From: [REDACTED]
Sent: 22 October 2024 14:32
To: Planning
Subject: Planning application 3/2024/0802

Planning Application Reference No.: 3/2024/0802

Address of Development: Warwick Street Longridge PR3 3EB

Proposed Ground Floor Plan

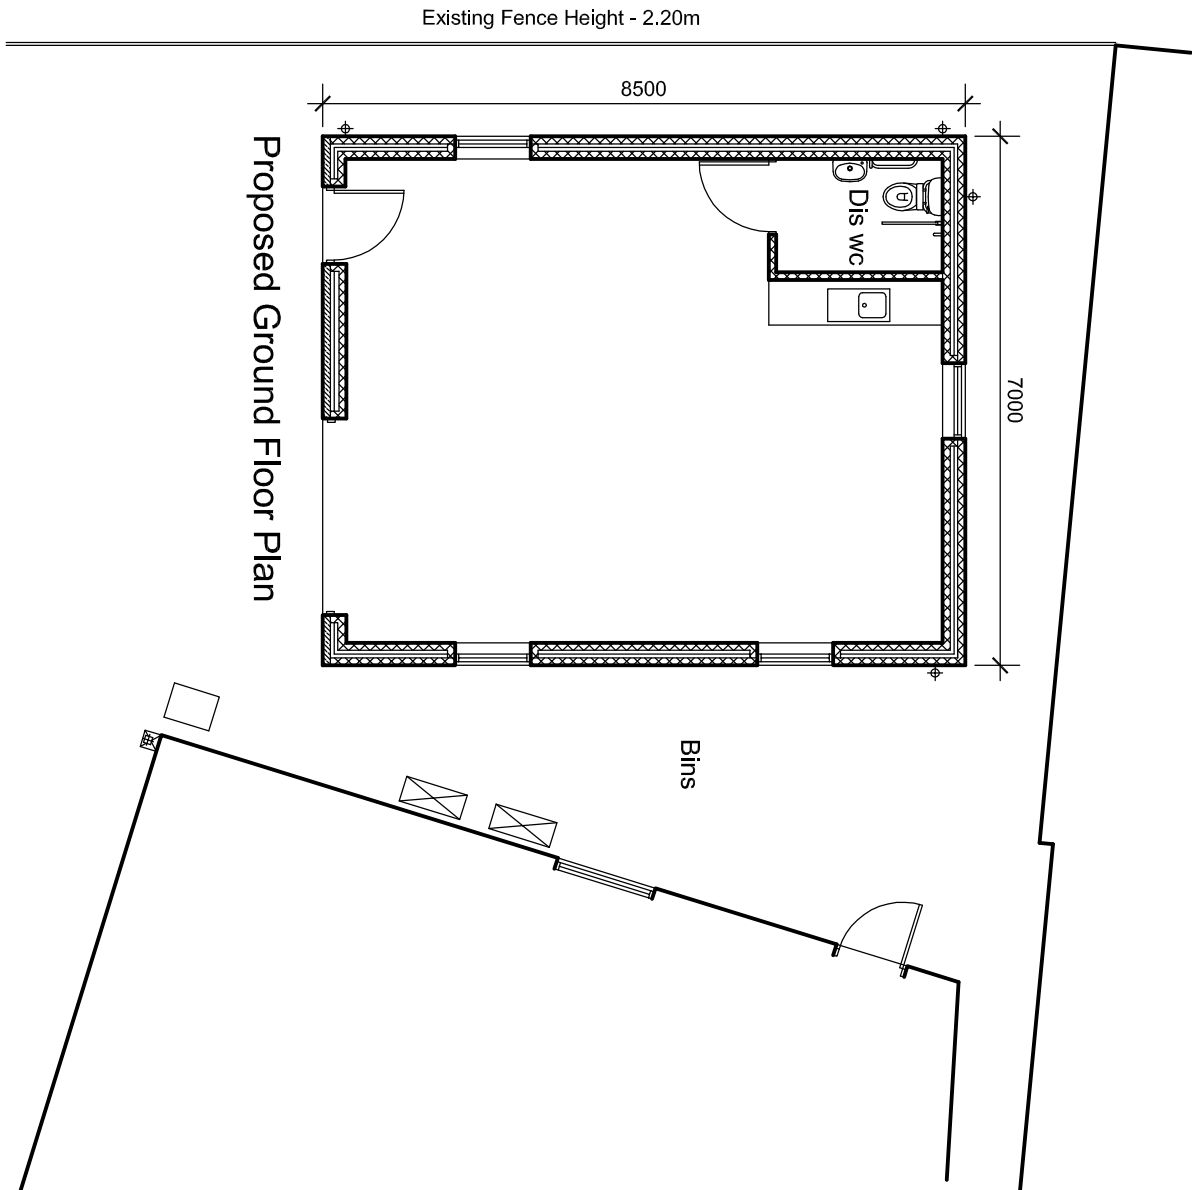
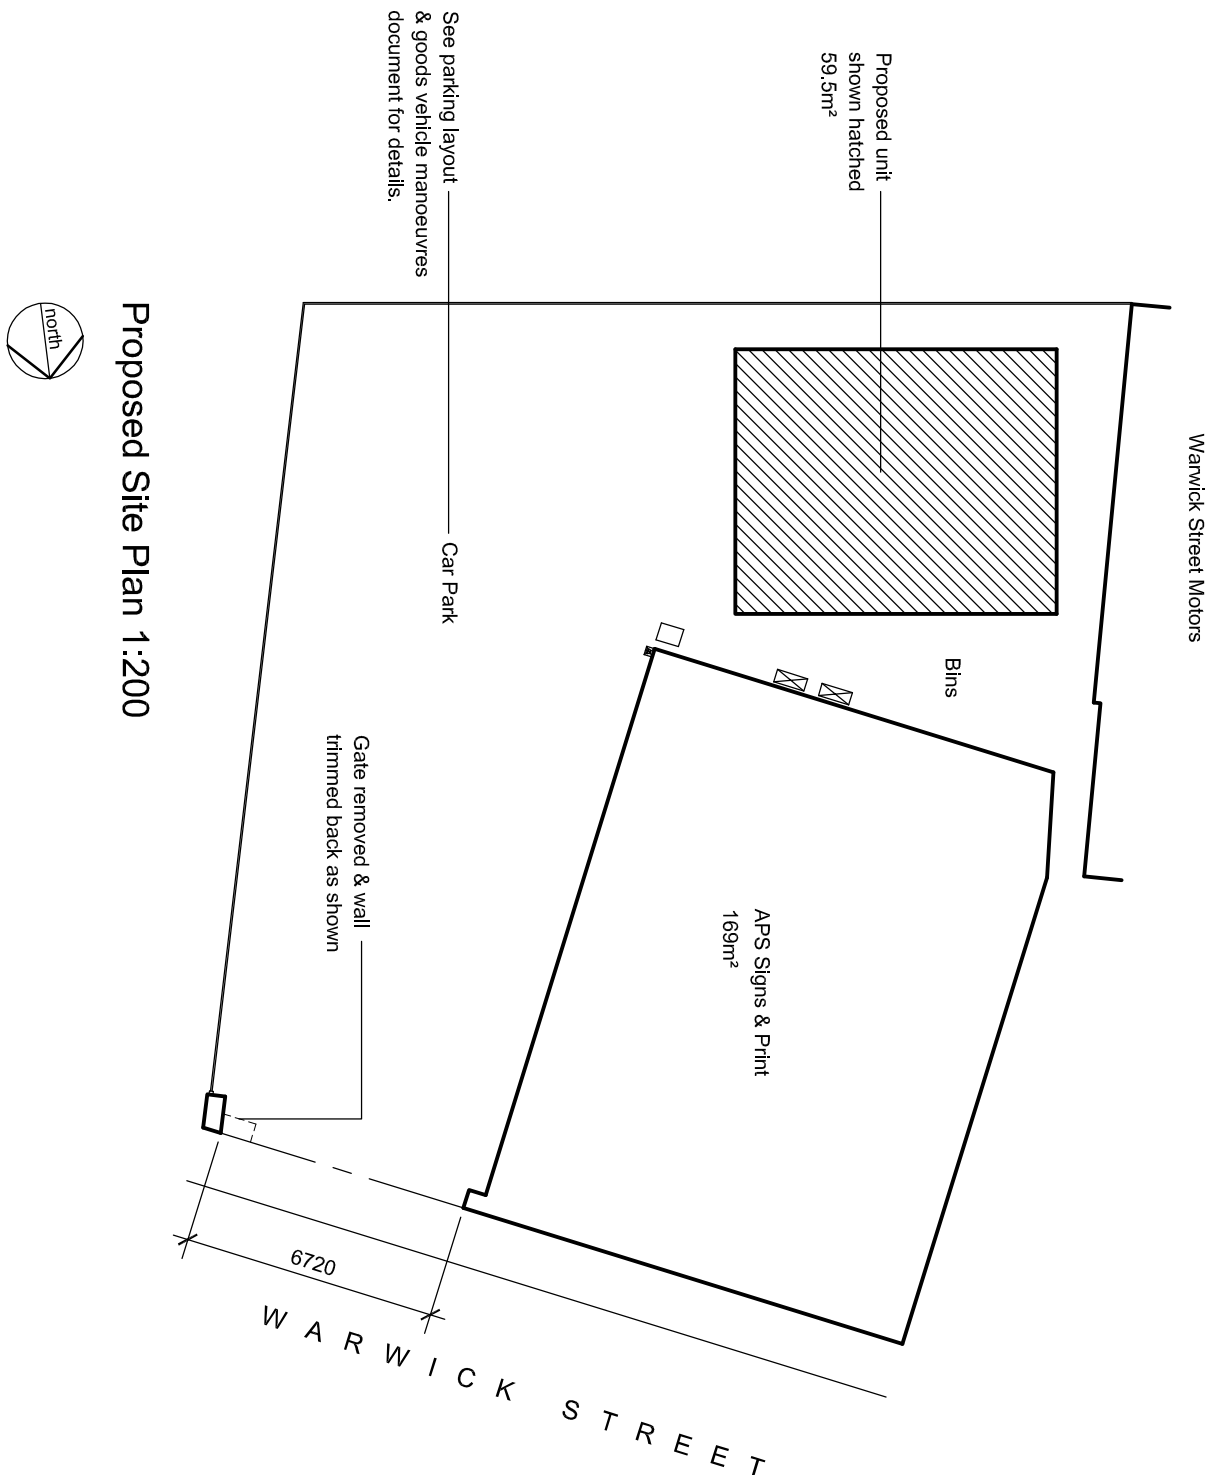
3. A previous proposal for this site was submitted in 2023, that provided the dimension of the proposed building to be 10.5m long x 7.1m wide (74.55m²) with minimum 1m clearance of the boundary fence to the south. The new proposal is given to be 8.5m long x 7m wide (59.5m²) with minimum clearance of 1m from the boundary fence to the south. Although this has been significantly reduced in length, this has only altered 0.1 in width from the previous planning application. This would, given the way the site is positioned be questioned. The existing building is place on the site at an angle, as can be seen from Google maps and Bing maps and also the proposed ground floor plan. This significantly restricts the spacing between the existing building and the boundary fence to the south. It would be disputed that, there is sufficient spacing, to place a building that is 7m wide, with a minimum of 1m on either side of the proposed building, between the boundary to the south and the front corner (east) of the existing building.

4. It is noted that on the original proposal there is WC facility provided, which sits in the middle of the north wall of the building. The new proposal, the WC facility is now situated in the back corner of the southern wall of the premises. It would therefore, be questioned as to where the soil pipe for this would be placed? This gives rise to serious concern that this could lead to issues for those resident in the bungalows nearest to this and their quite enjoyment of their rear gardens, that abut the southern boundary, in the summer months.
